PROJECT NO. 2020-004757

DESCRIPTION: Resubmittal to the Development Review Board after addressing comments from the  
initial review meeting on March 31, 2021.

**RE: RV Storage – Albuquerque: DRB Resubmission**

## **COMMENT RESPONSE LETTER**

RV STORAGE - ALBUQUERQUE
ALBUQUERQUE, NEW MEXICO
SITE PLAN
SITE PLAN

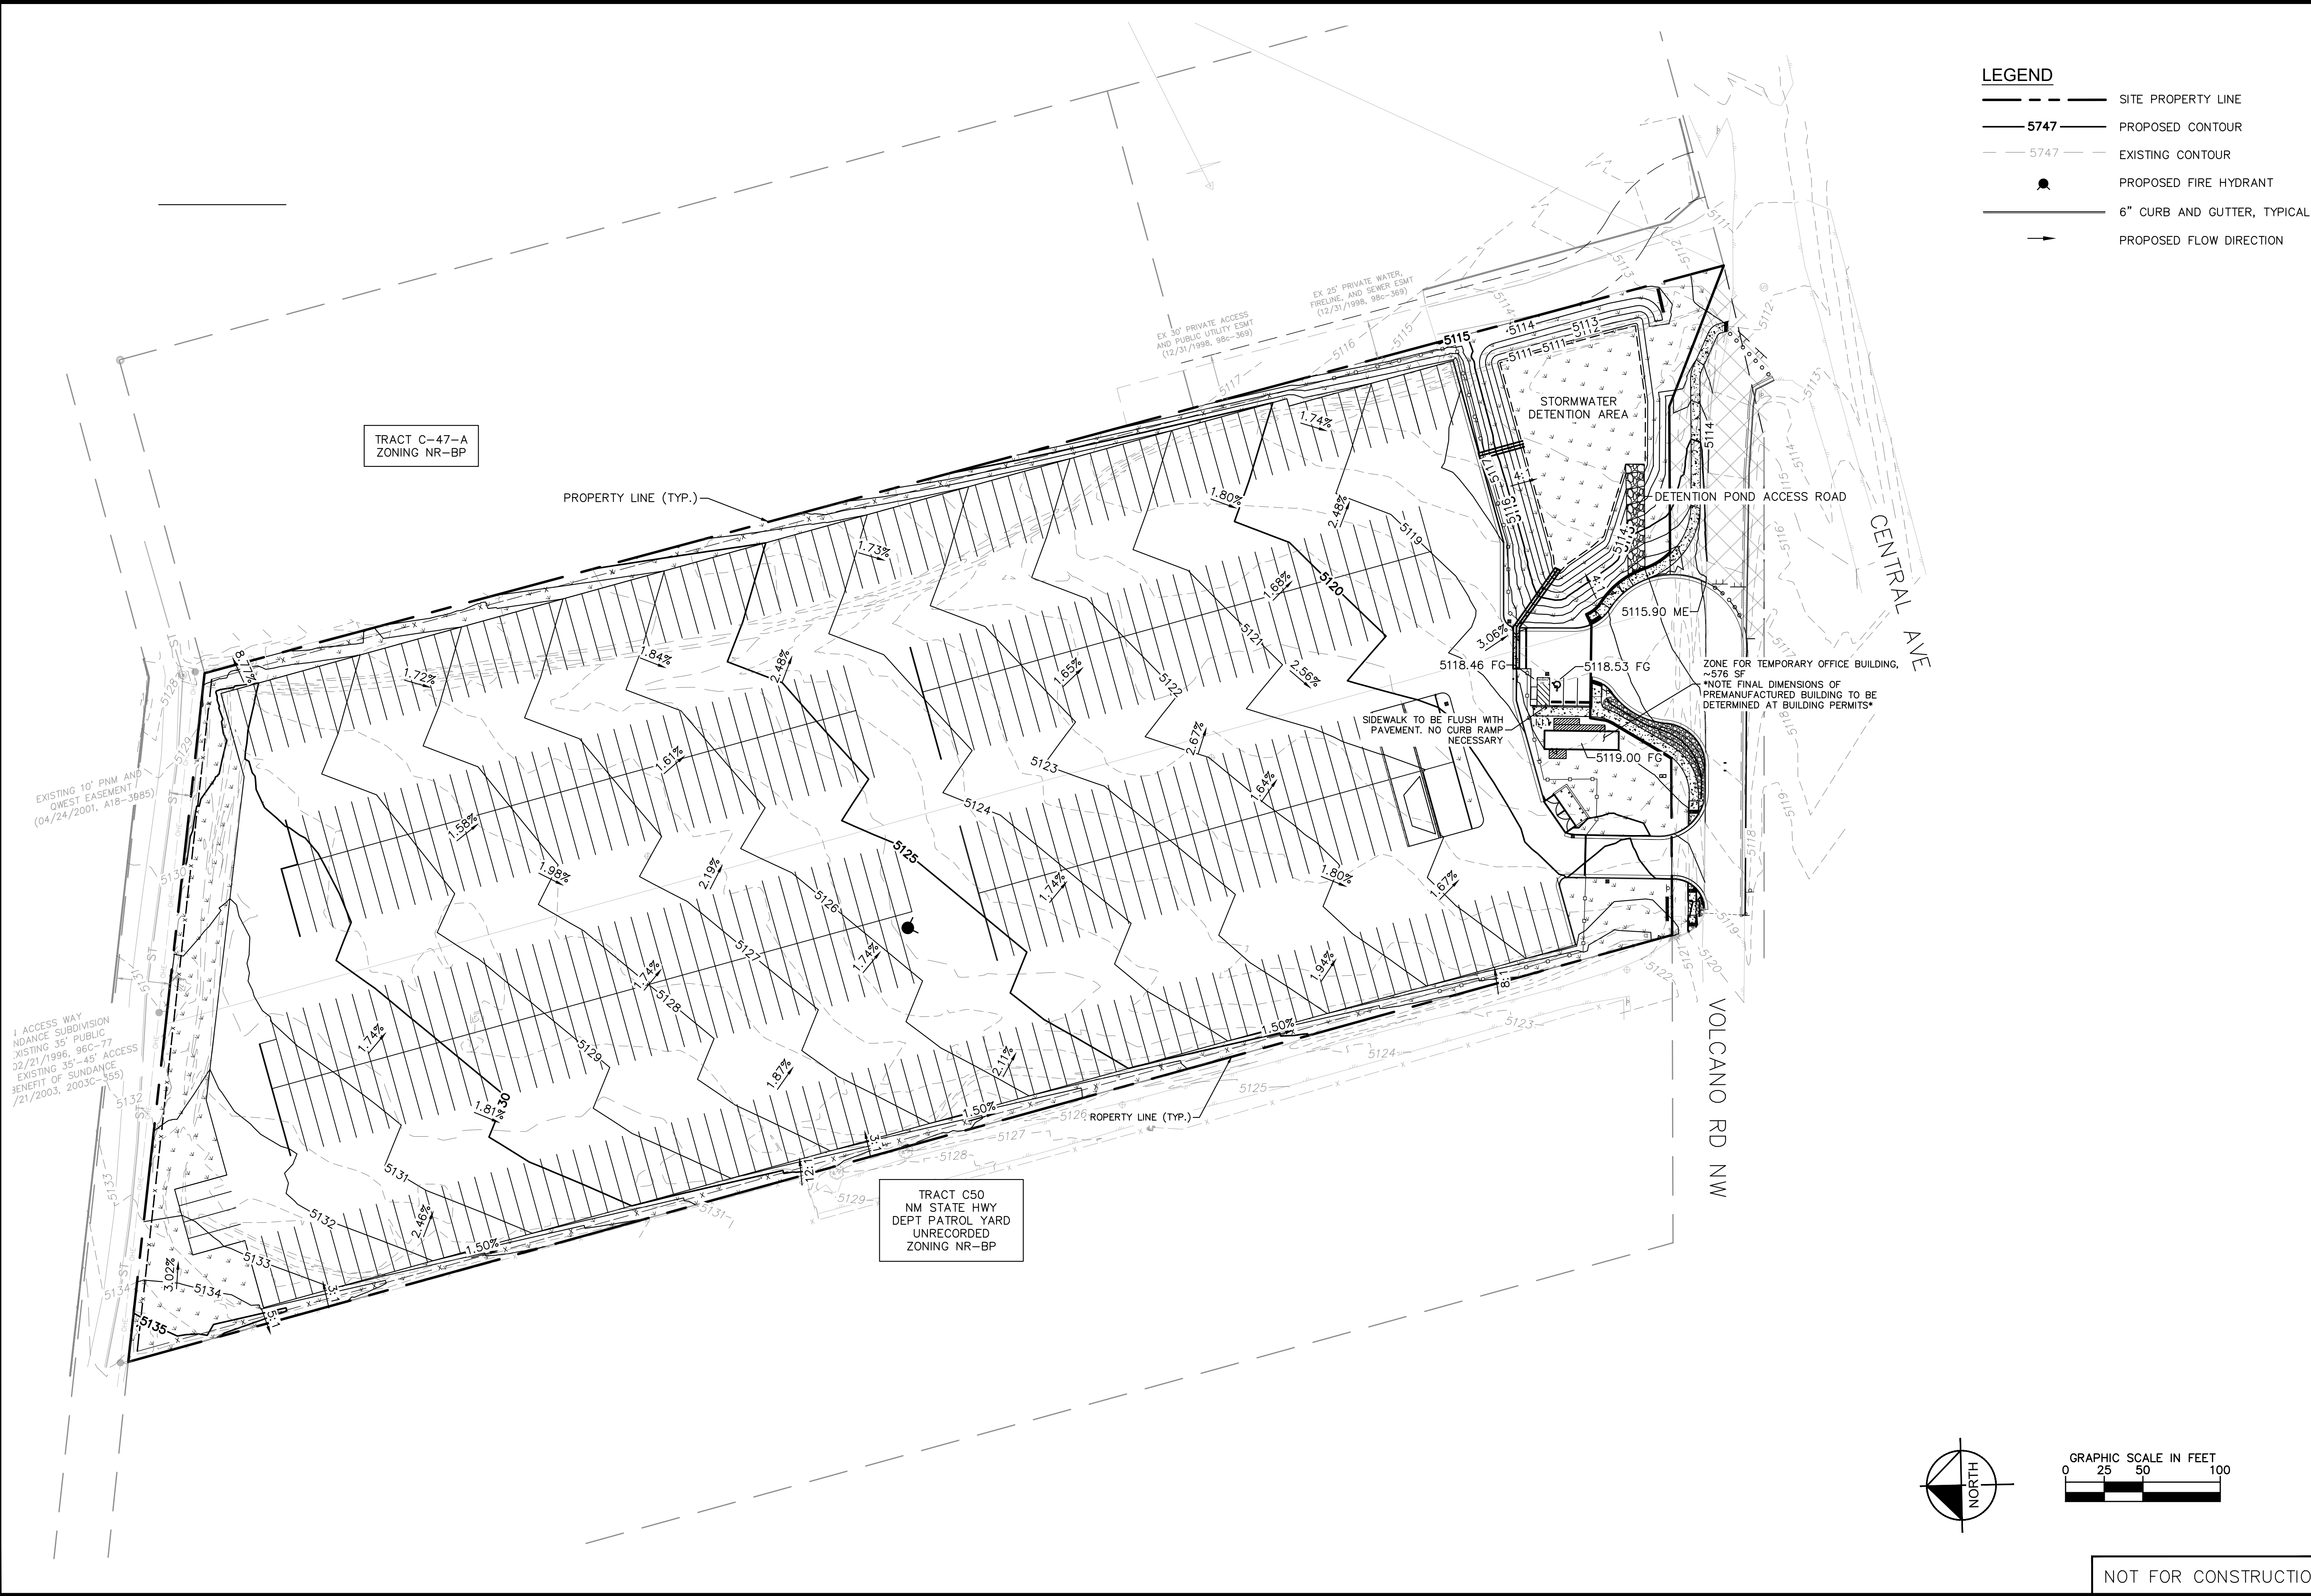
1. DMD is opposed to the Volcano Rd access and alignment as shown on the site plan. Alternatives to this design were previously discussed with the applicant.
  - *Response: Acknowledged. The design has been adjusted and updated on the site plan.*

1. There were two options given for this development which include either a request for vacation of right-of-way and a subsequent creation of a dead-end cul-de-sac or a an extension of Volcano Road to the neighboring driveway to match up with the existing median cut. (This is due to the fact that Volcano Road does not meet current DPM standards for intersection/driveway spacing or the intersection roadway alignment.)

- *Response: Acknowledged. Sidewalk and curb have been adjusted and a roadway cross-section has been added.*
4. Indicate how the parking spaces are designated for the storage facility on the drawing. Will these be painted parking spaces?

5. For the ADA parking and turn-around for the RV parking before the gate, provide dimensioning for the parking spaces and parking aisle. (For the turn-around itself, also provide a turning template design.)

7. Include clear sight distance triangles at the accessway. Include standard note for landscaping limits. "Landscaping, fencing and signing will not interfere with clear sight requirements. Therefore, signs, walls, trees, and shrubbery between 3 and 8 feet tall (as measured from the gutter pan) will not be acceptable in the clear sight triangle."

8. Provide 6-foot ADA access from the office to the right-of-way and from the office to the handicapped spaces. Include any sidewalk and ramp details as necessary. Label sidewalk at a 2% slope.
  - *Response: Acknowledged. A 6-foot sidewalk has been included.*
9. The ADA access aisle shall have the words "NO PARKING" in capital letters, each of which shall be at least one foot high and at least two inches wide, placed at the rear of the parking space so as to be close to where an adjacent vehicle's rear tire would be placed. (66-1-4.1.B NMSA 1978)
  - *Response: Acknowledged. This requirement has been shown on the site plan.*
10. The ADA accessible parking sign must have the required language per 66-7-352.4C NMSA 1978 "Violators Are Subject to a Fine and/or Towing."
  - *Response: Acknowledged. An ADA parking sign detail has been added.*

5. Confirm wall details.
  - *Response: A 6' fence has been added around the edge of the site.*
6. If right-of-way is dedicated, a replat will be required.

- *Response: Acknowledged. The vacation of right-of-way request is being submitted to DRB for approval and the design has been updated to include a dead-end cul-de-sac.*

- *Response: The parking spaces will not be painted to provide storage flexibility. Signage will be mounted from the canopies designating storage locations.*

- *Response: Acknowledged. Dimensioning has been added to the plans and a turning template has been included.*
6. Provide parking calculations for the proposed parking shown. This should include any requirements from the IDO including ADA parking, motorcycle parking, and bicycle parking. Provide handicapped space signage, motorcycle parking signage, and a bike rack detail.

- *Response: Acknowledged. This note has been included.*

**RV STORAGE - ALBUQUERQUE
 ALBUQUERQUE, NEW MEXICO
 SITE PLAN
 GRADING AND DRAINAGE PLAN**

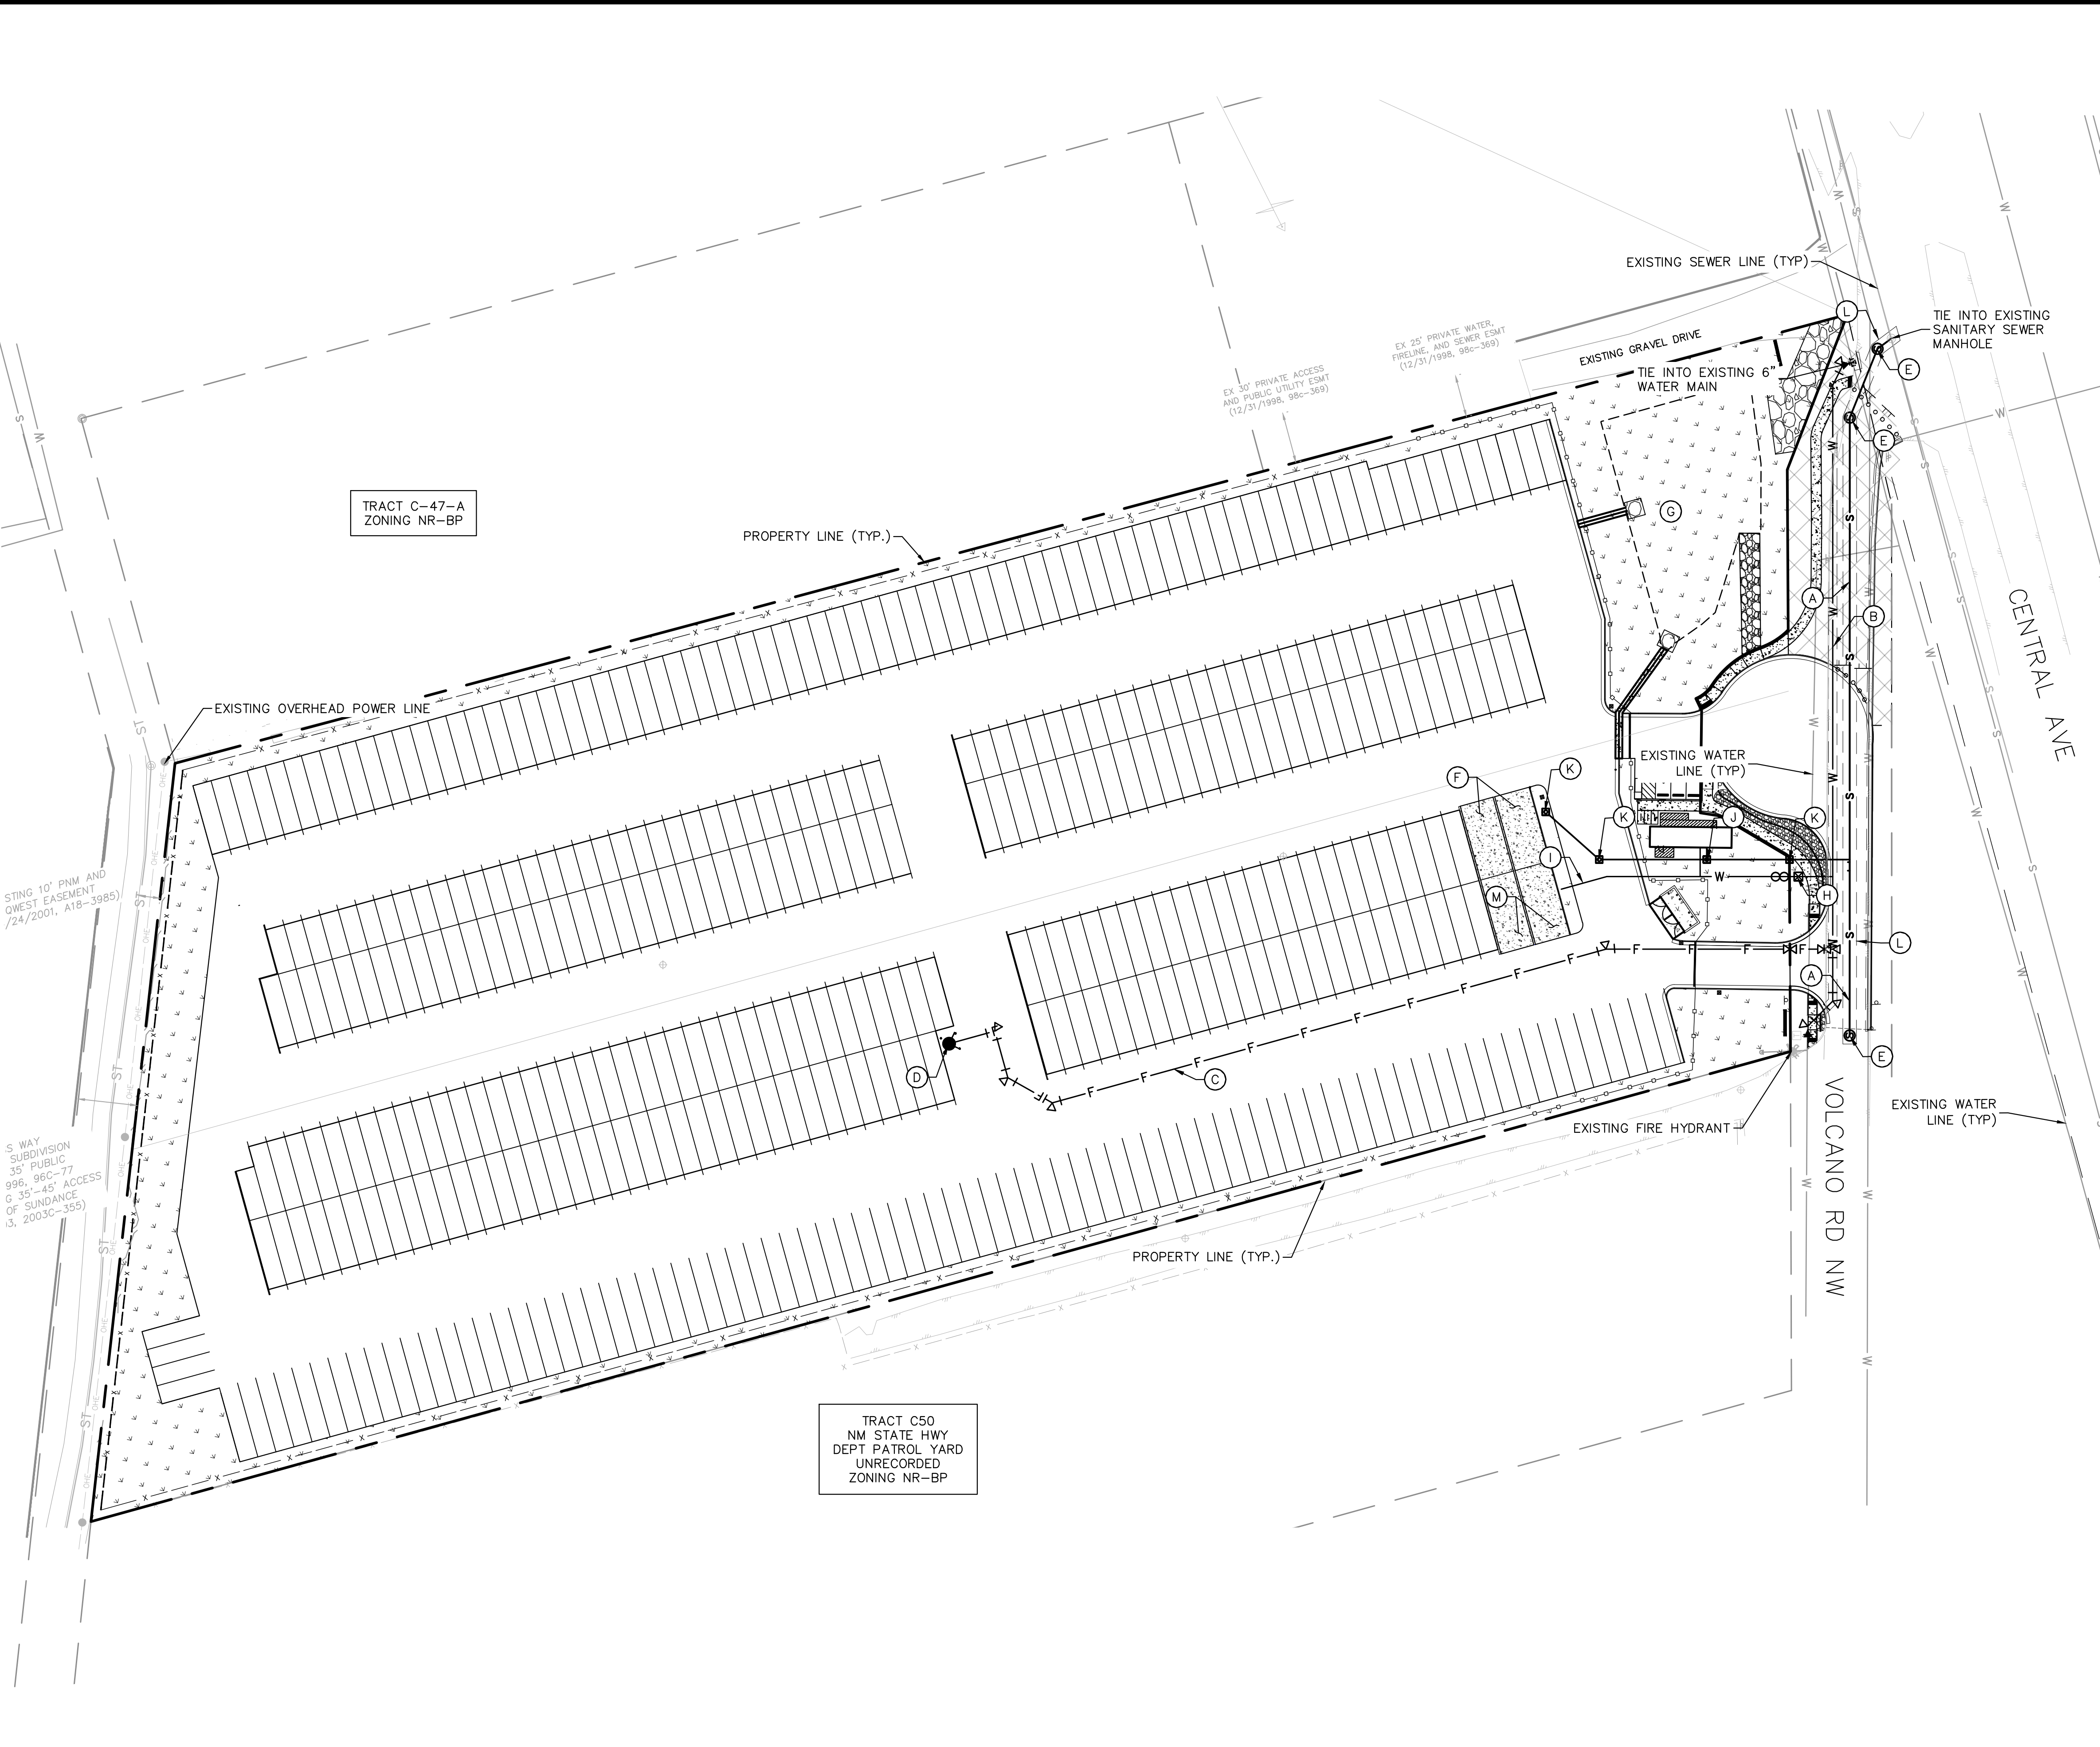
1. Hydrology will need to approve the Grading & Drainage Plan prior to approval of Preliminary Plat or Site Plan for Subdivision.
  - *Response: Acknowledged. This is currently being reviewed.*
2. The infrastructure list may be needed.
  - *Response: Acknowledged. The infrastructure list has been completed and included.*
3. Comment - Hydrology will need to approve the Grading & Drainage Plan prior to Building Permit if one of these conditions is met. (500 cy of grading, 1,000 sf of proposed building, or 10,000 sf of proposed paving).
  - *Response: Acknowledged. This is currently being reviewed.*
